NC DEPARTMENT OF  
**HEALTH AND  
HUMAN SERVICES**

October 26, 2023

RE: Popeyes Louisiana Kitchen  
1517 NC 24-97  
Cameron, NC 28326

This letter acknowledges review of the revised plans for the above referenced establishment. The revised plans dated 09/04/23, revised application, email correspondence (responses) are conditionally approved with the following comments:

Drawn NI	Checked AH
Scale 1/4" = 1'-0"	Date JUNE 2023
Project No. C22-129	Drawing No. P2.1

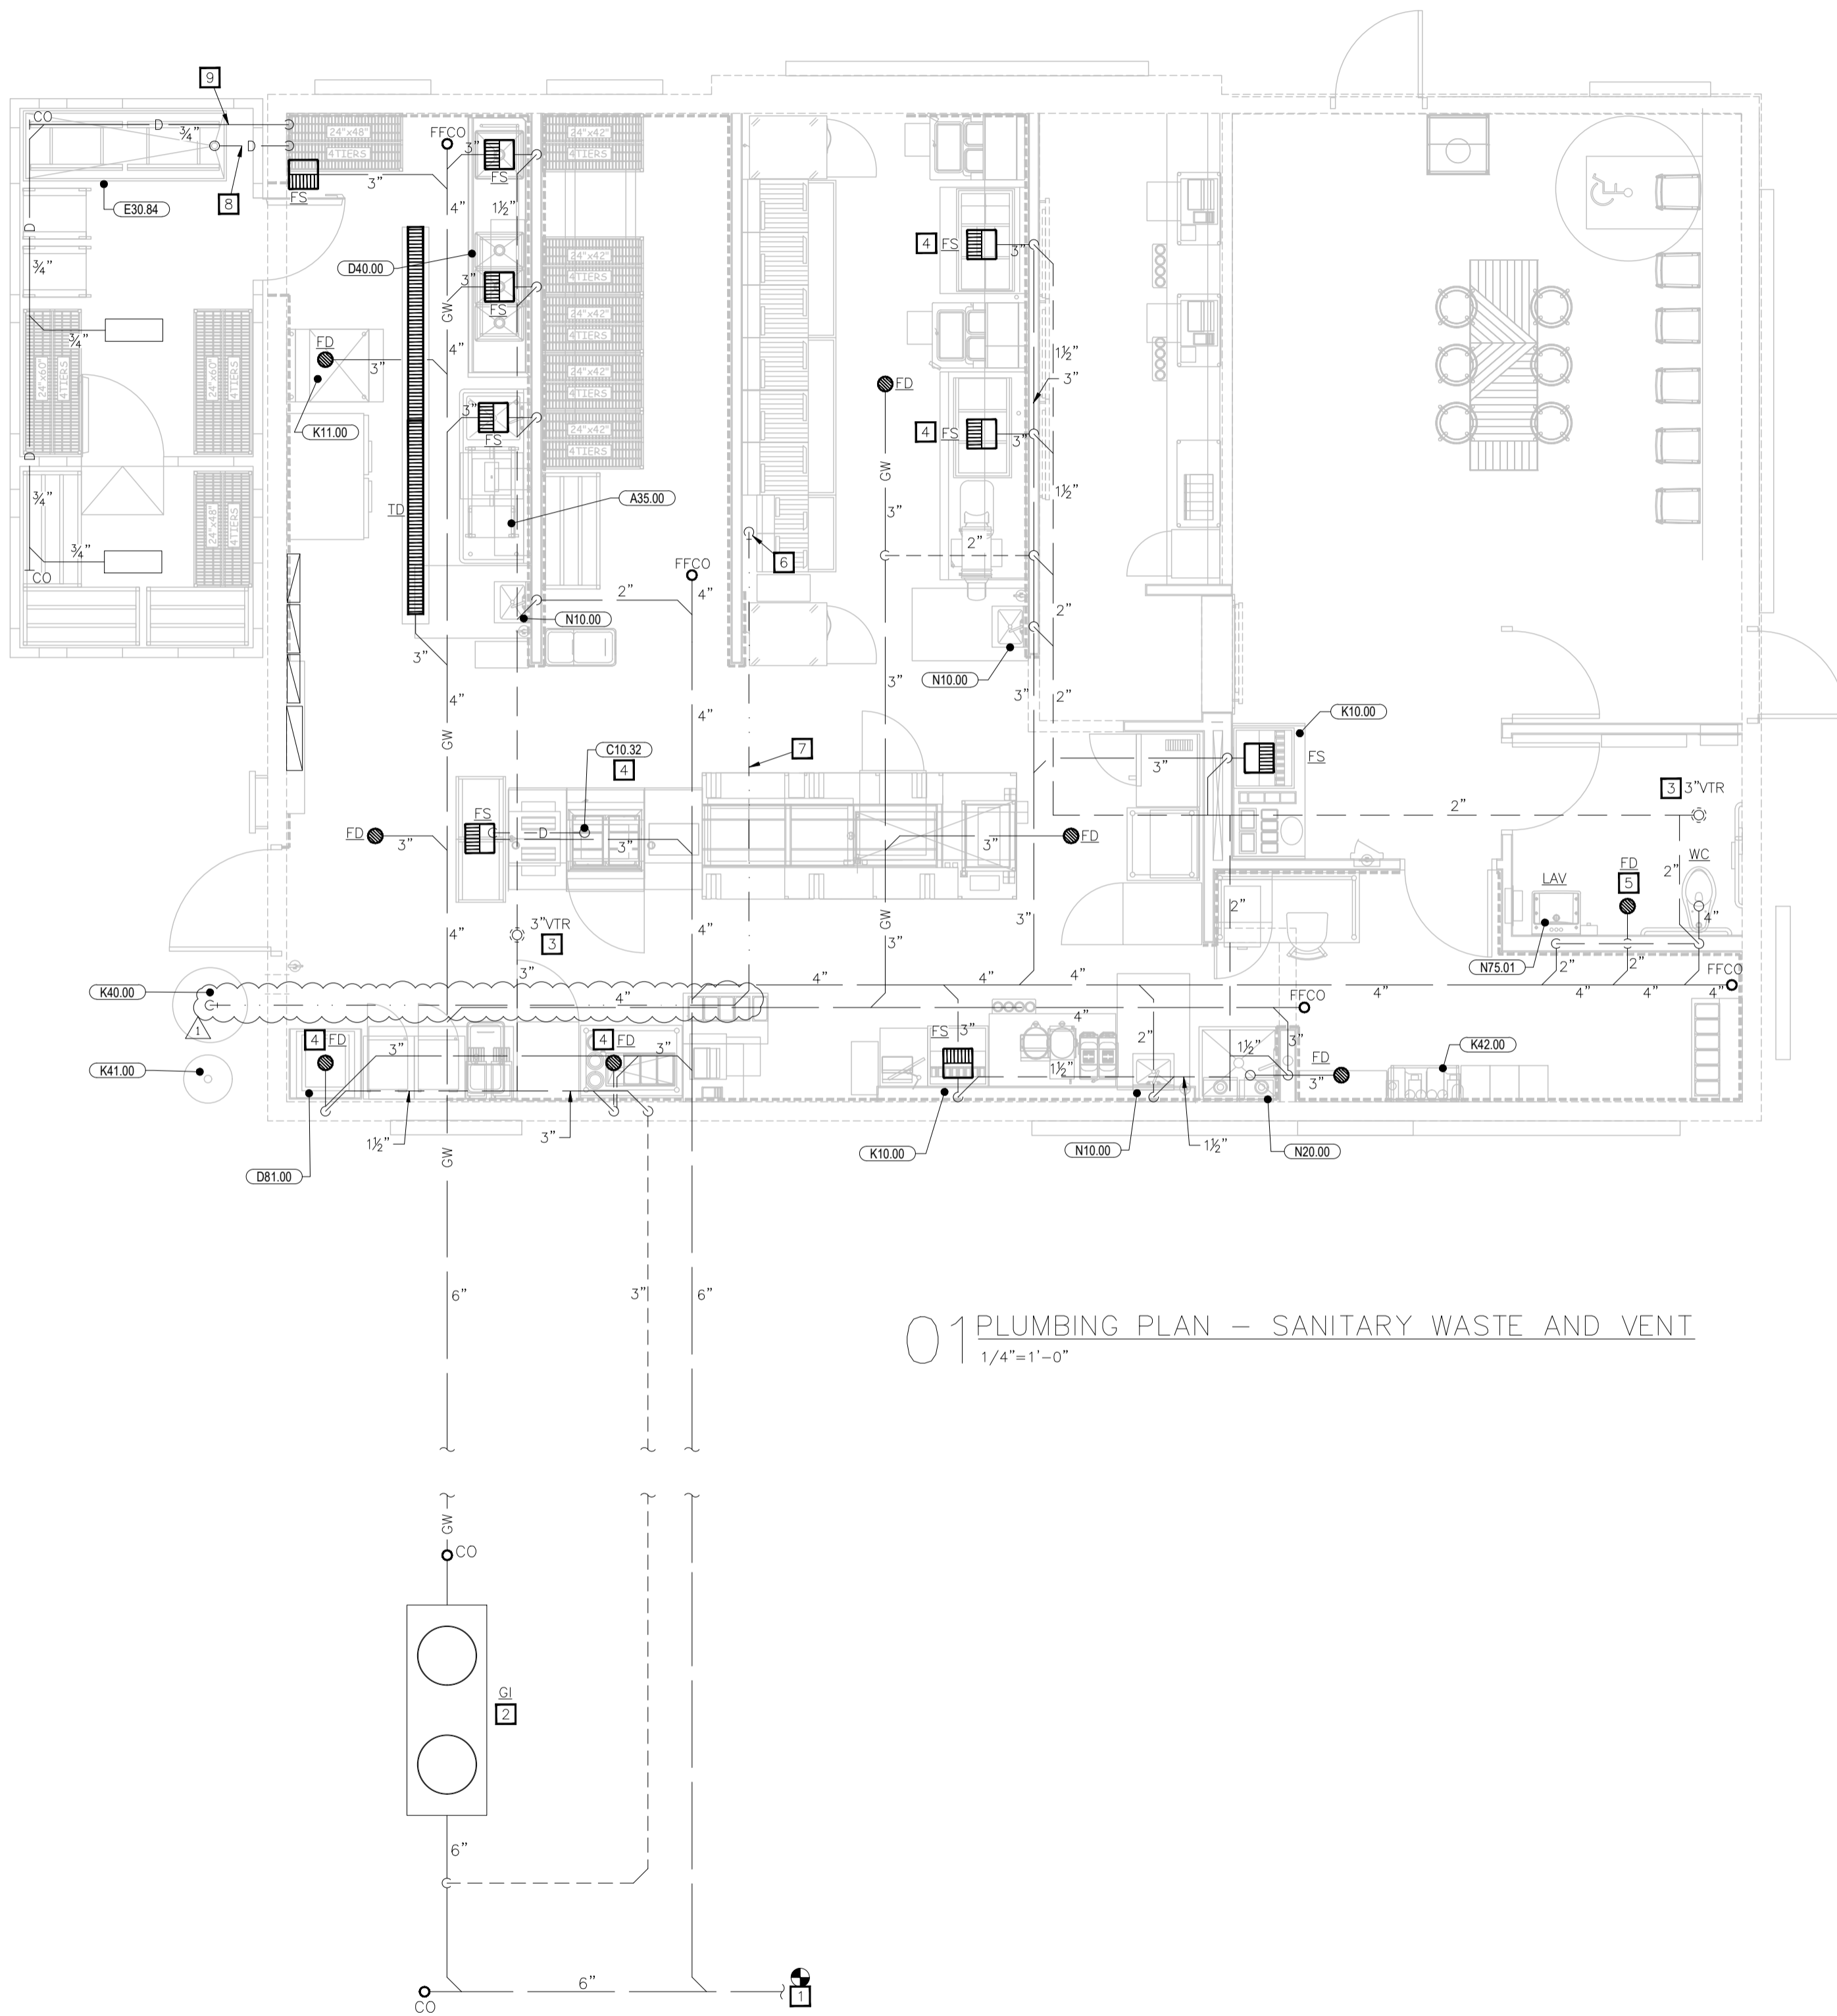
3. The plumbing waste and water plans revised 10/27/23 are approved provided they comply with Parts 5-1 and 5-2 and Parts 6-3, 6-4 and 6-5 of the Food Code. The 120 gallon/18Kw water heater specified on the application, plan sheets P1.1, P2.1 revised 10/27/23, and email correspondence is approved provided it is sufficient to meet peak hot water demand of the establishment. Future increases in hot water using fixtures may require additional hot water capacity. The water heater should be installed to allow for cleaning in accordance with provisions referenced in paragraph 2 (a) above.
